SNPA ExQ1 Responses

Question 17.5 – SNPA and NRW raise concerns around under-reporting of significant effects. Please identify specifically where your concerns lie, with supporting reasons for this

Question 17.6 – SNPA’s RR makes reference to visual impacts from specific points within the National Park, such as from Carnedd Llywelyn and the Carneddau as a whole. Noting that VP10 is from Carnedd Llywelyn and VP is from Foel Fras;

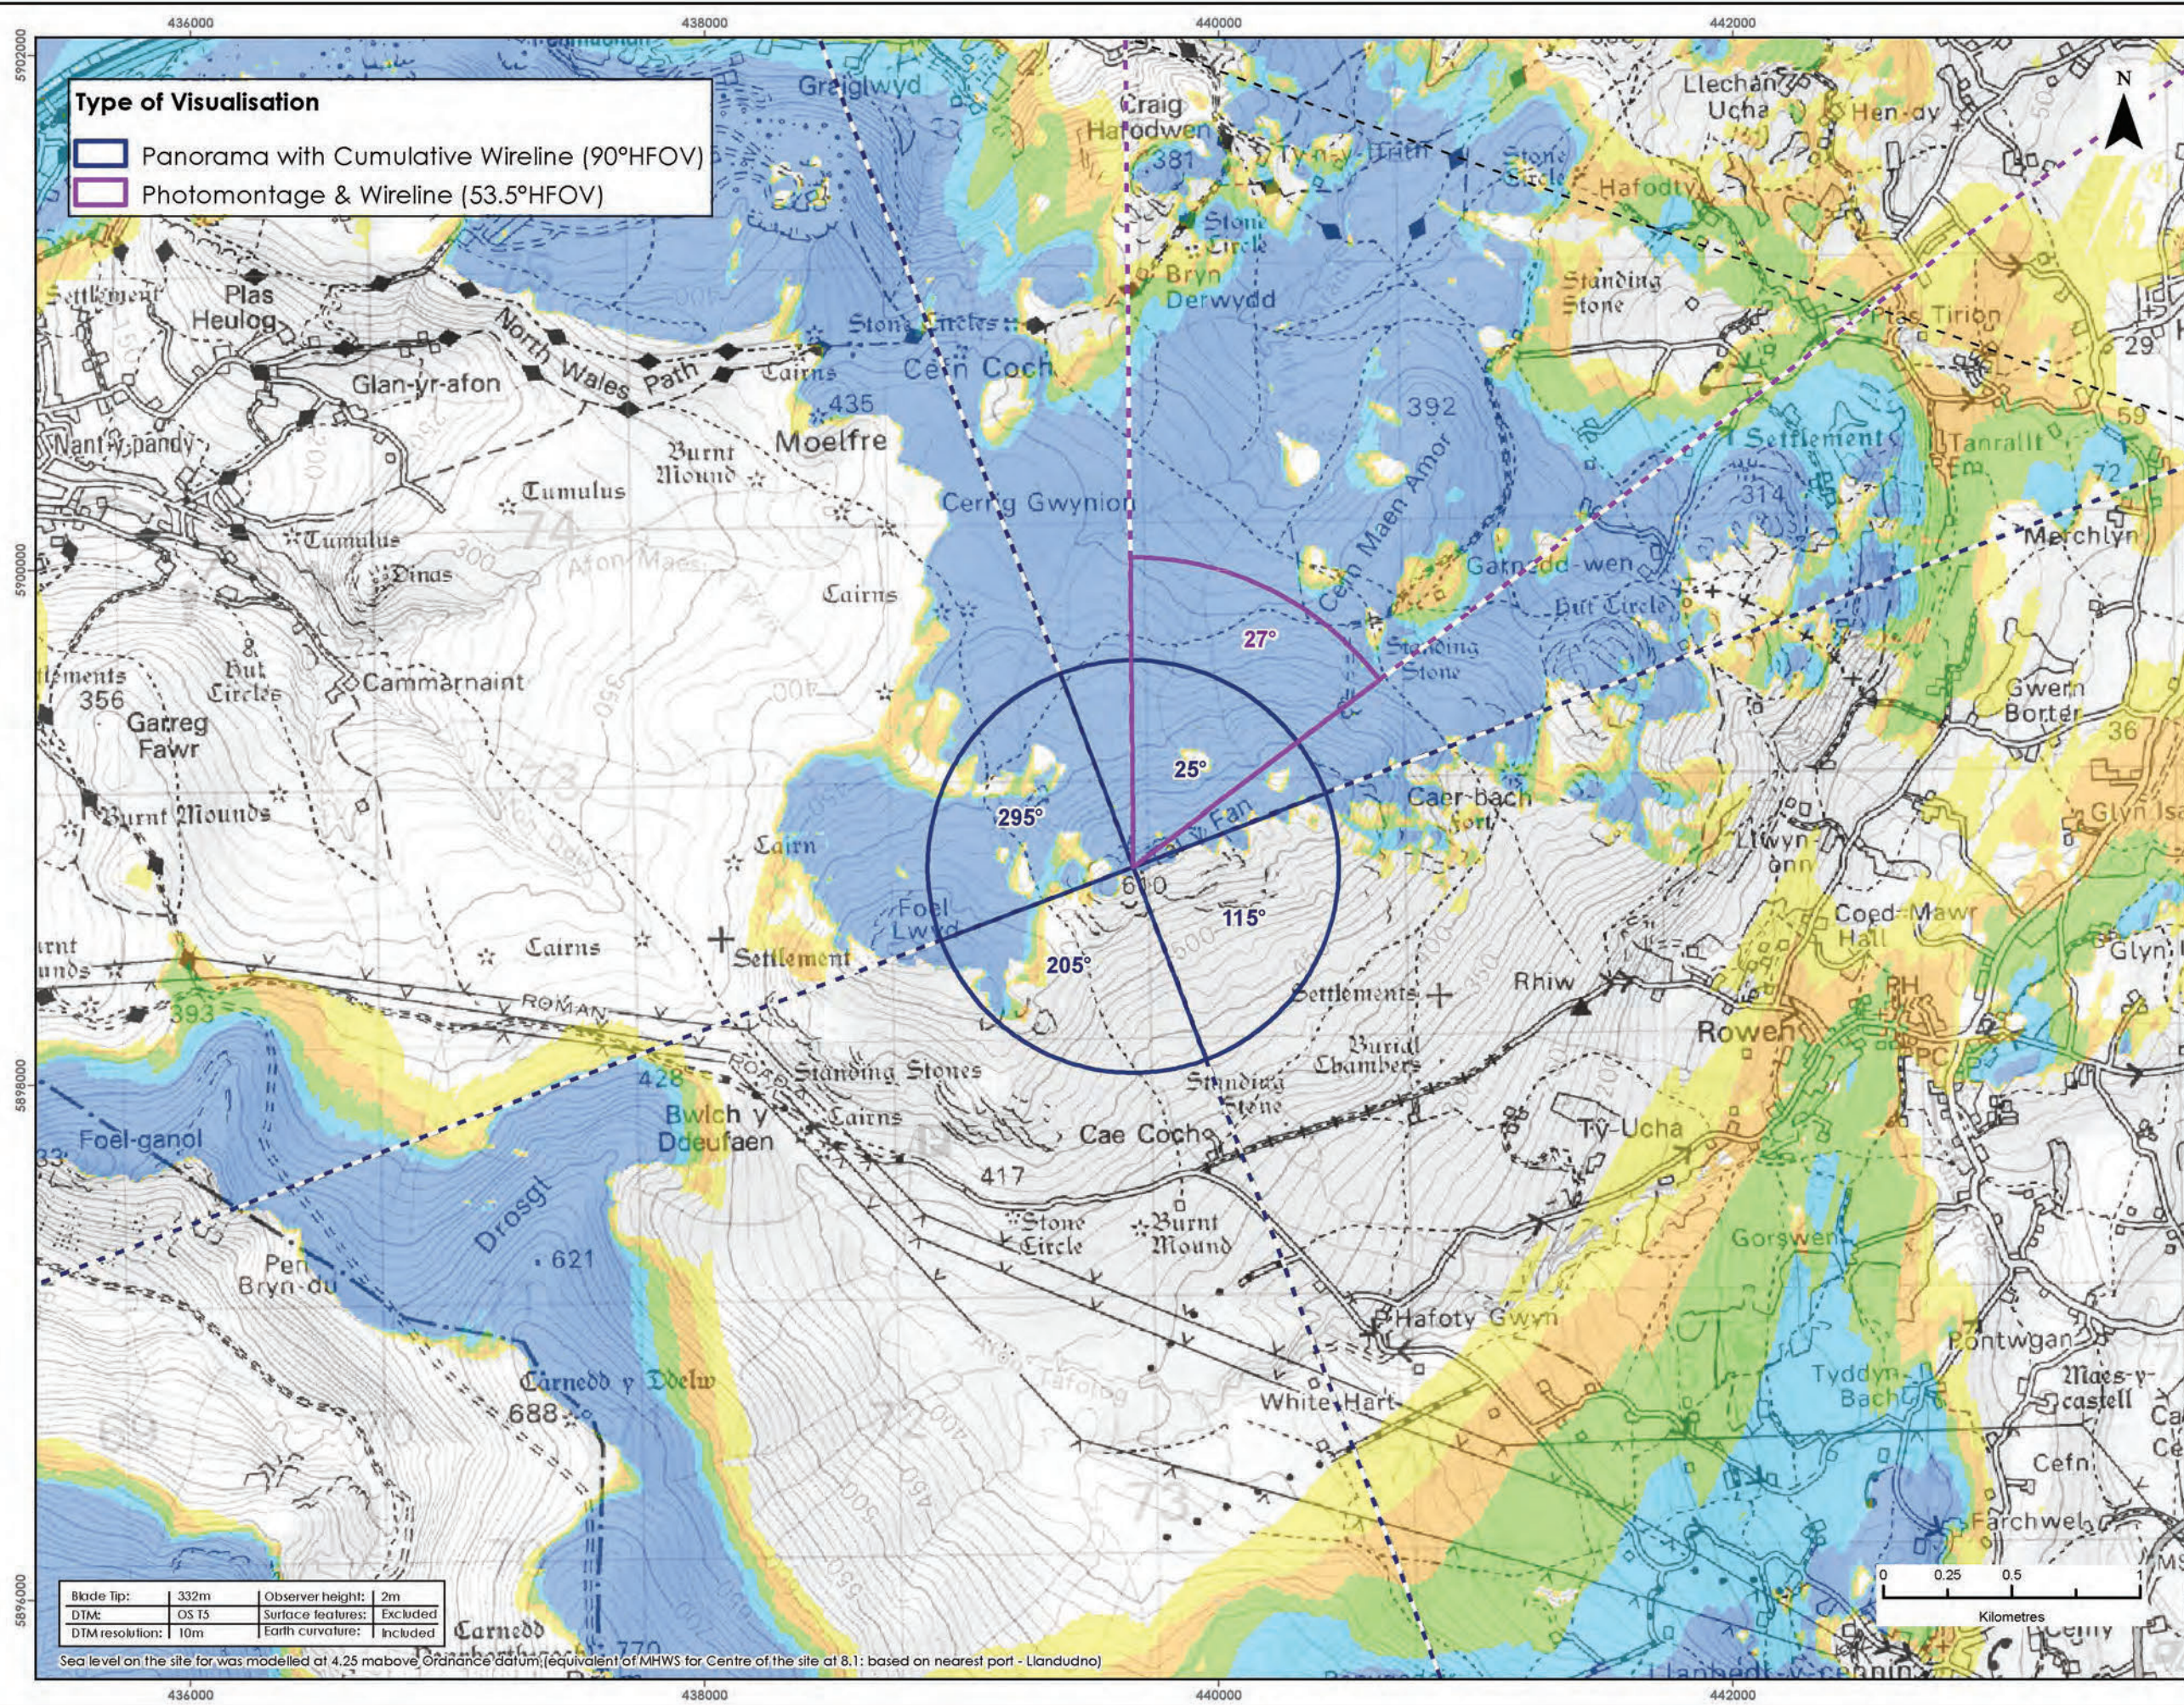
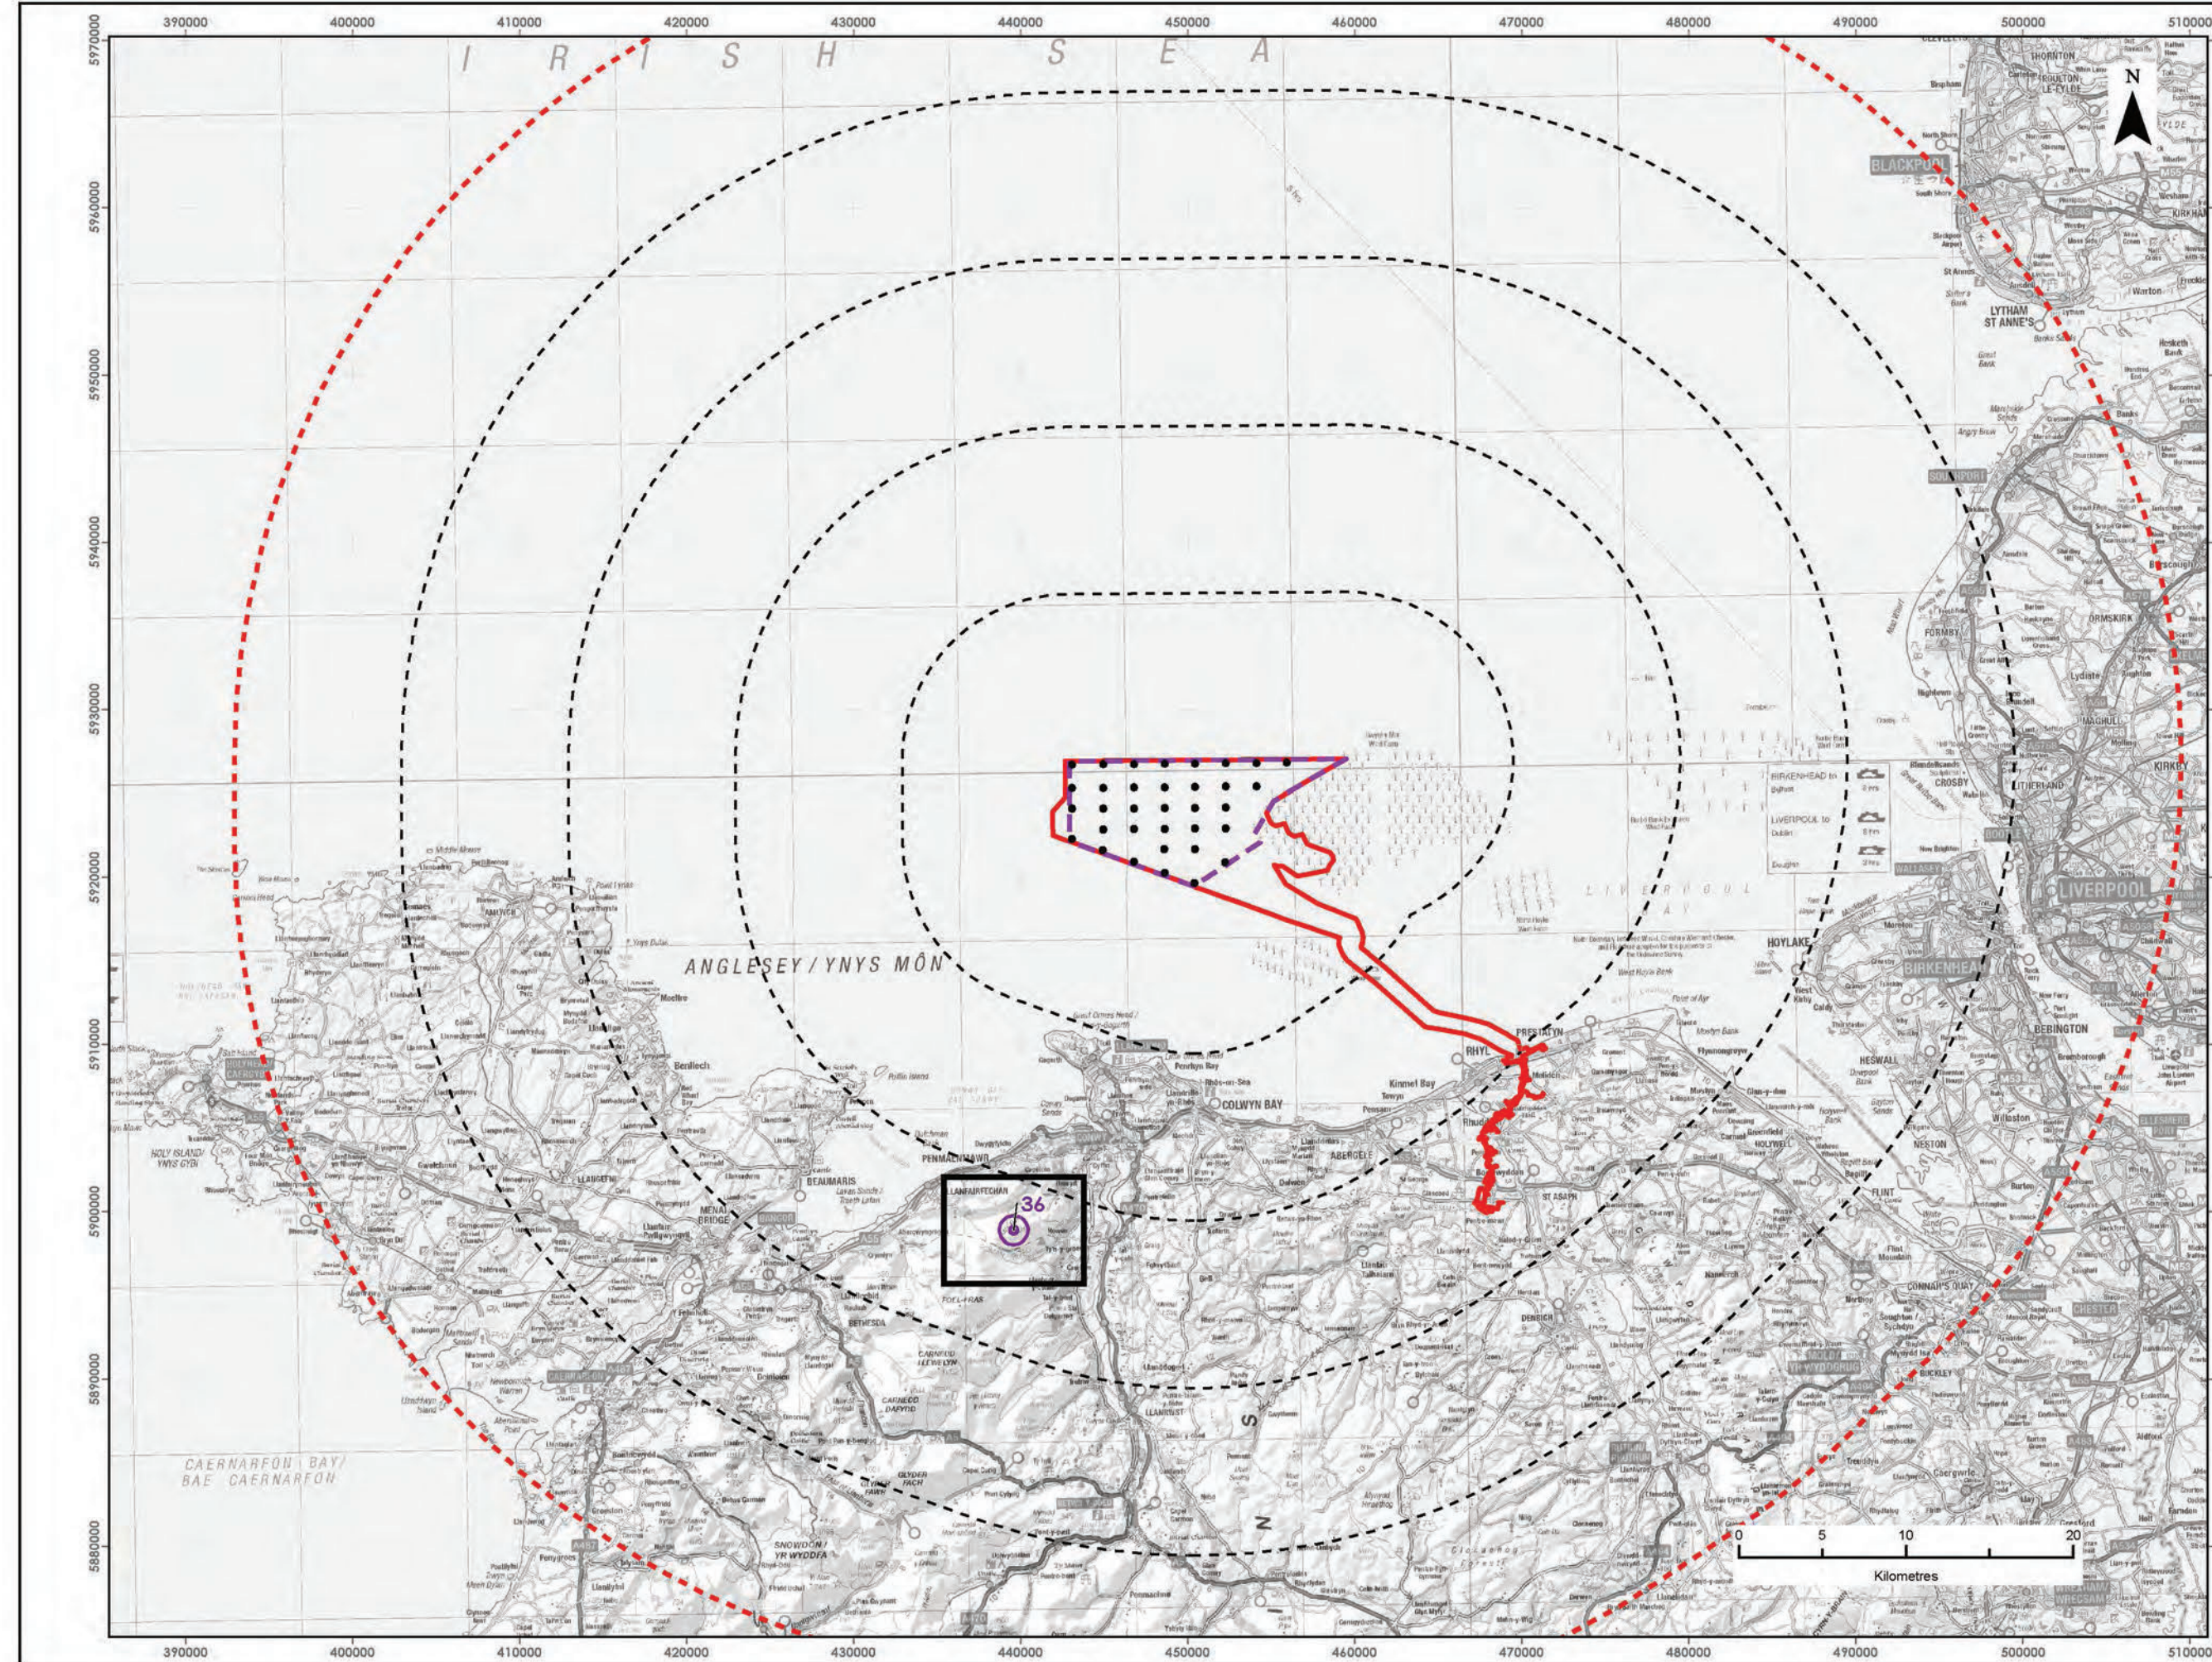
- The PEIR found significant effects at four of these, while we queried the finding of non-significant at VP36 Tal-y-Fan. Effects on the closer viewpoints 12 and 40 are recorded as major- moderate in the ES, with the more distant viewpoints 10 and 38 being moderate. A moderate-minor and non-significant effect is recorded at VP34 Snowdon Summit. The assessment for VP36 Tal-y-Fan is stated to be moderate but not significant. We suggest that, although close to the borderline, this should be identified as significant. We note that effects at VP38 Foel-fras are moderate (significant), on a very similar but more distant view. We highlight an inconsistency in the sensitivity assessment for VP36 that may account for this
